CITY OF ALBUQUERQUE

August 10, 2021

Re: Rio Grande Credit Union-4th Street
1211 4th St NW
Traffic Circulation Layout
Engineer's Stamp 08-04-2021 (J14-D163)

File Name: P:\data\2020\2020.044-7\ENG\2020447-Design\Bases-RCGM.dwg - C-101-R3 Plot Date: 3/23/22 Plot Time: 09:20

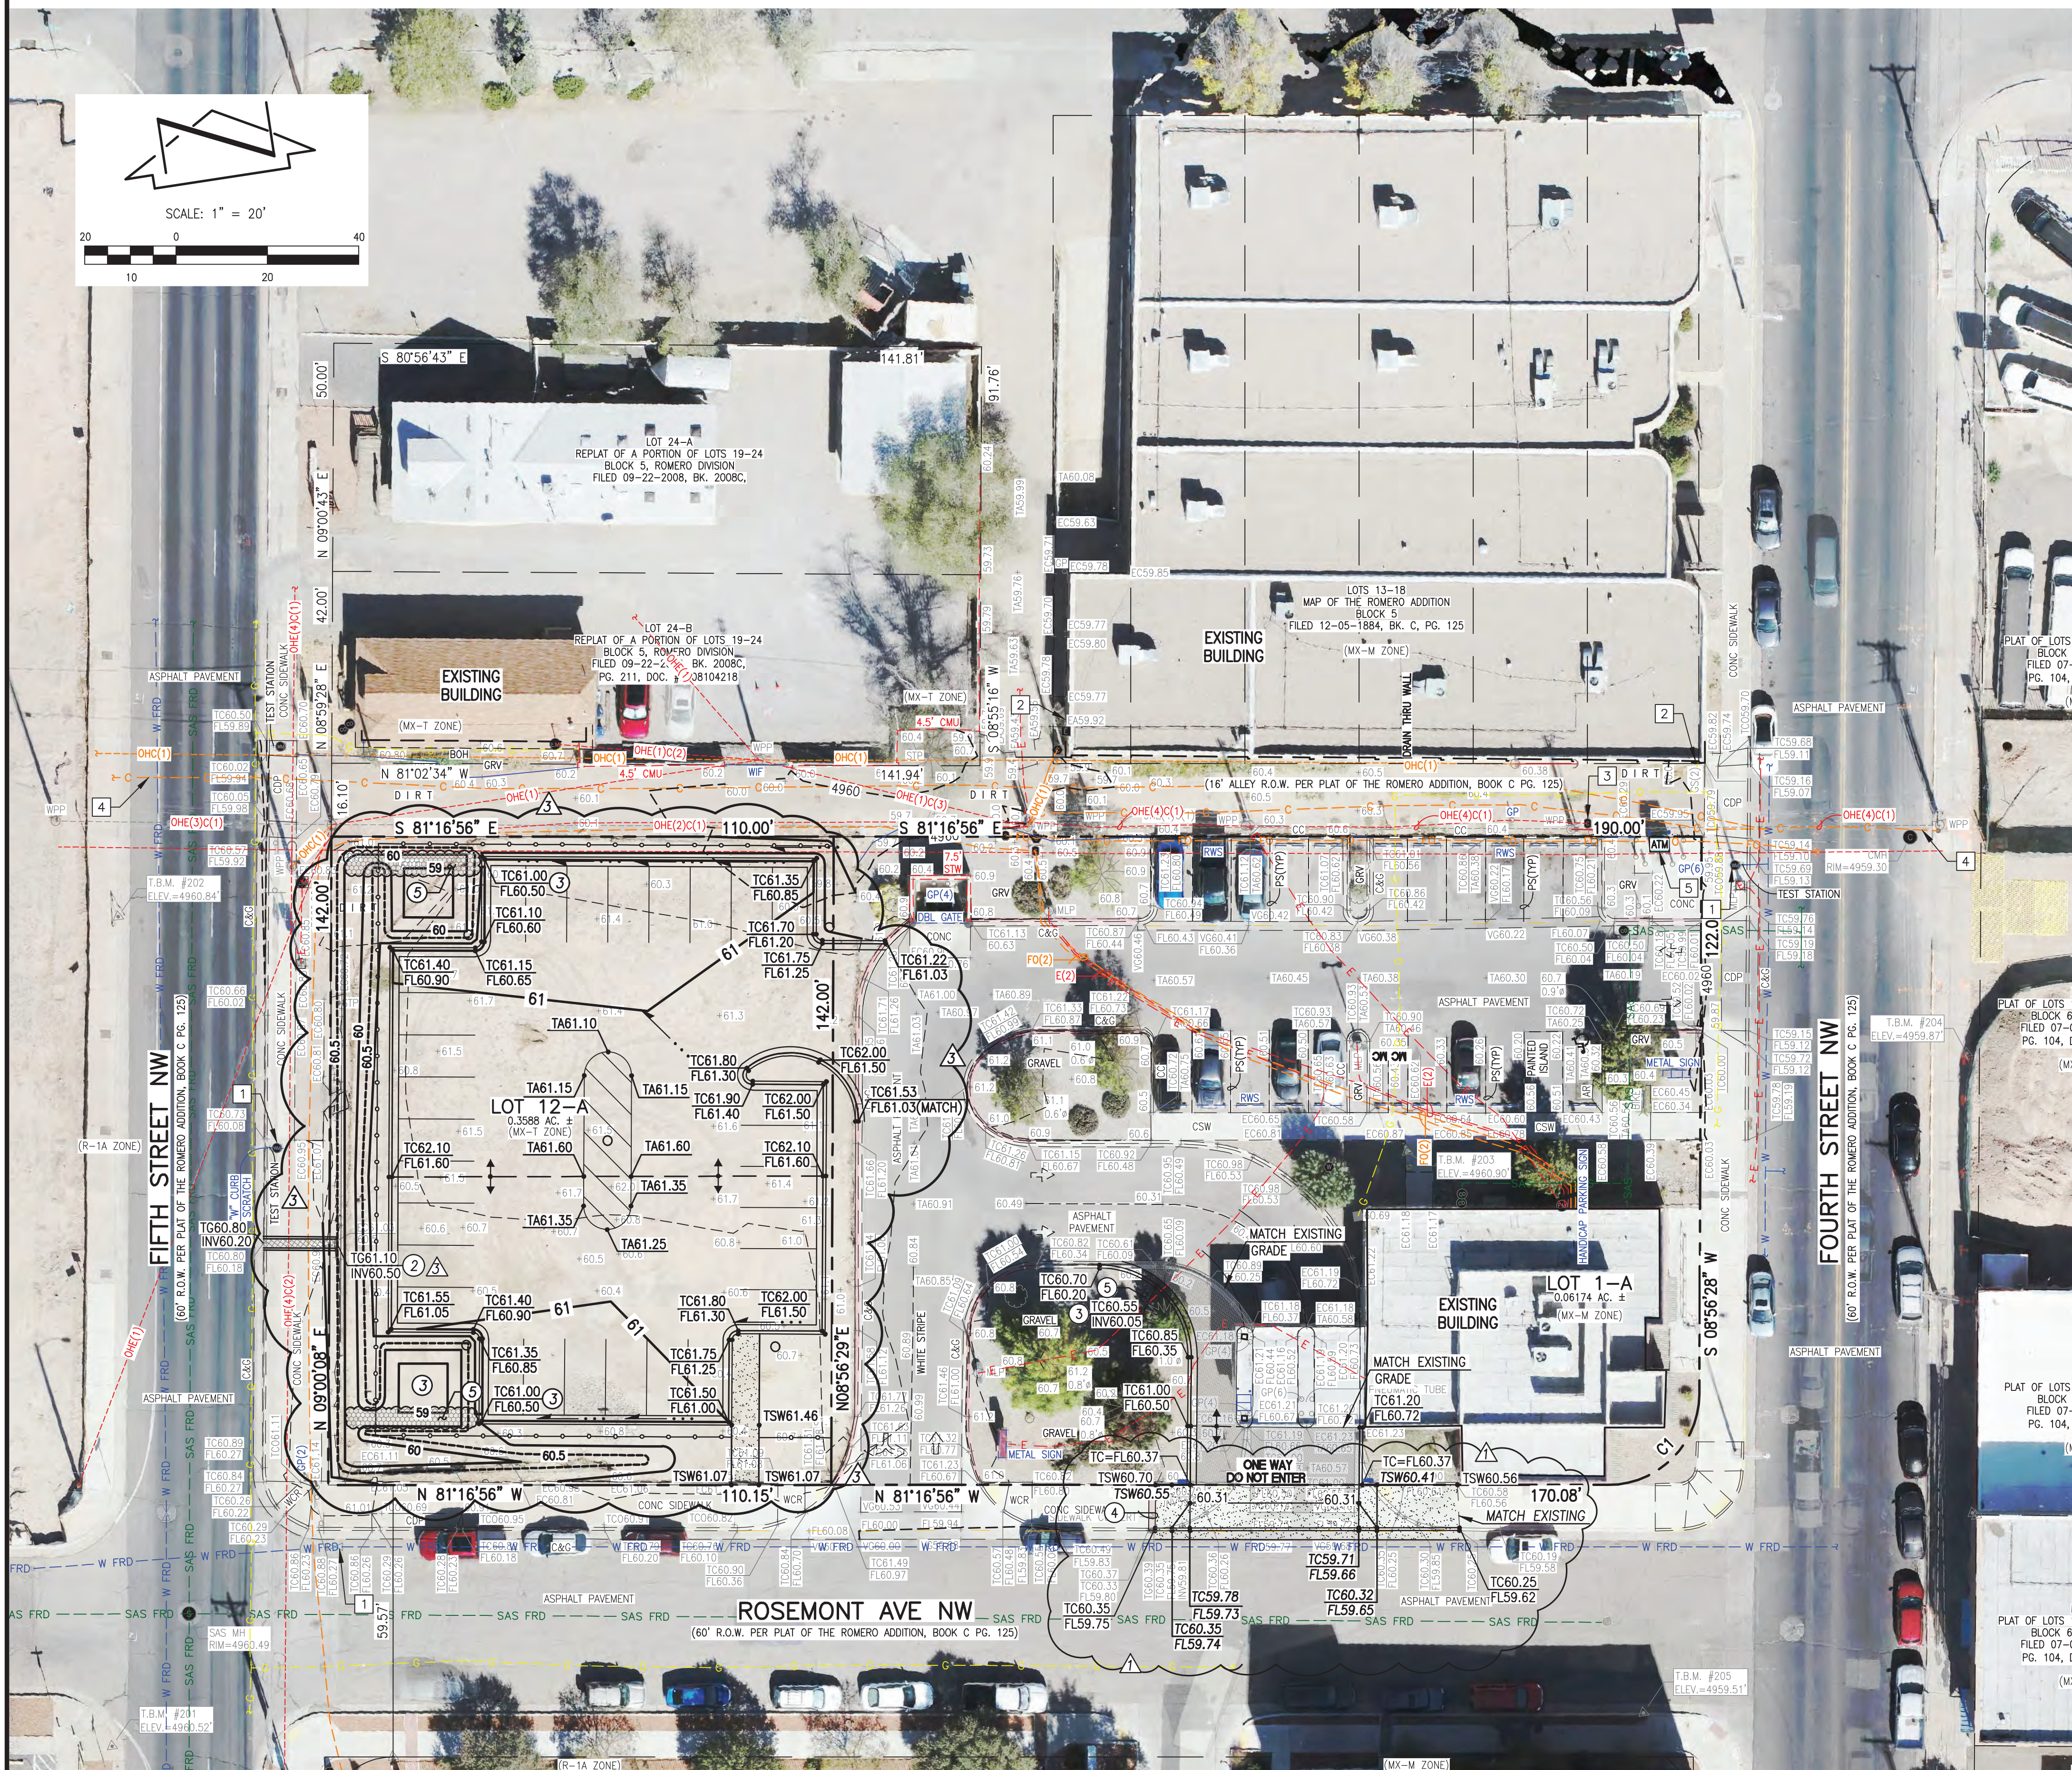
3. Label the parking spaces by placing the words "**COMPACT**" on the pavement for each space that doesn't meet the minimum **STANDARD** parking stall dimensions.
4. **ADA Parking stall and Access aisles:**
 - The ADA access aisles shall have the words "NO PARKING" in capital letters, each of which shall be at least one foot high and at least two inches wide, placed at the rear of the parking space so as to be close to where an adjacent vehicle's rear tire would be placed. The existing pavement markings are barely visible and will need to be remarked.
 - The ADA symbol on the parking stall is barely visible and will need to be remarked
 - Provide keyed notes for the above remarkings of pavement marking.
5. **Rosemont/5th St. Corner Ramp:**
 - The existing ramp is not ADA and updated to current standards and have truncated domes installed.

**TYPICAL SIGN AND POST DETAIL**  
NOT TO SCALE

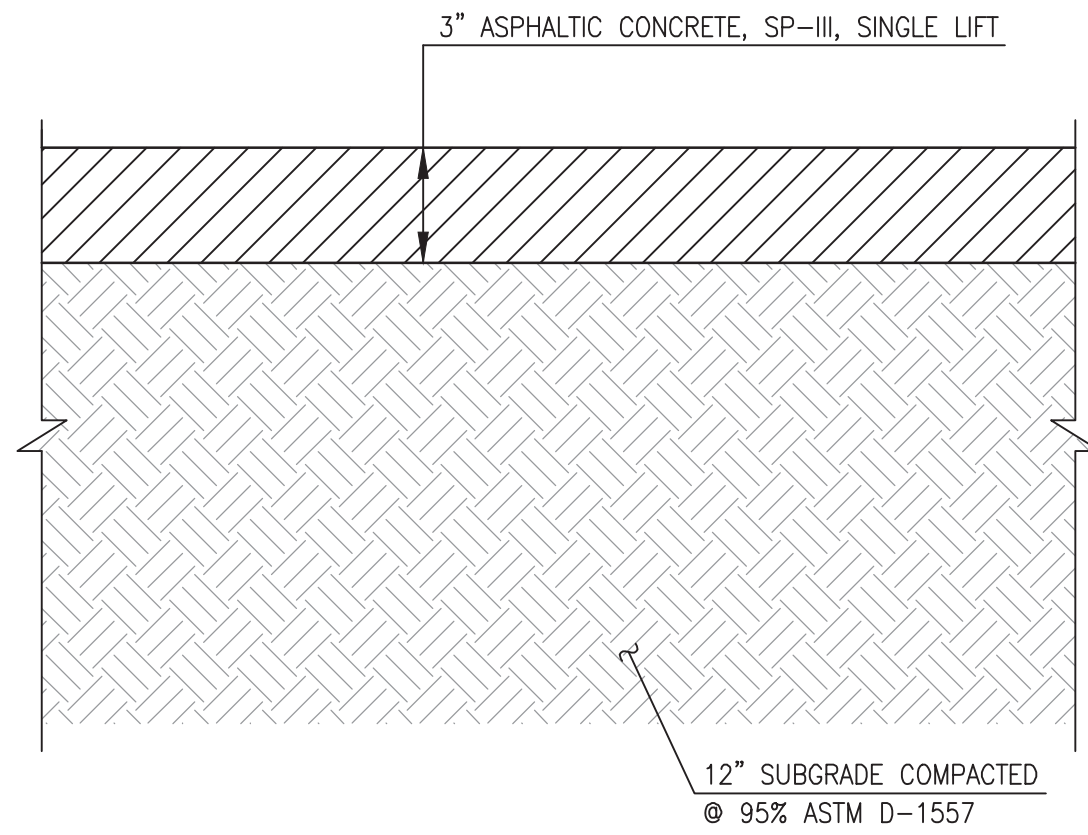
1. Please provide **SIGN POST AND SIGN FACE DETAIL** for all proposed signage on sheet C-102 for drive thru lanes. Show details on sheet C-501.
2. The minimum parking stall dimensions are:
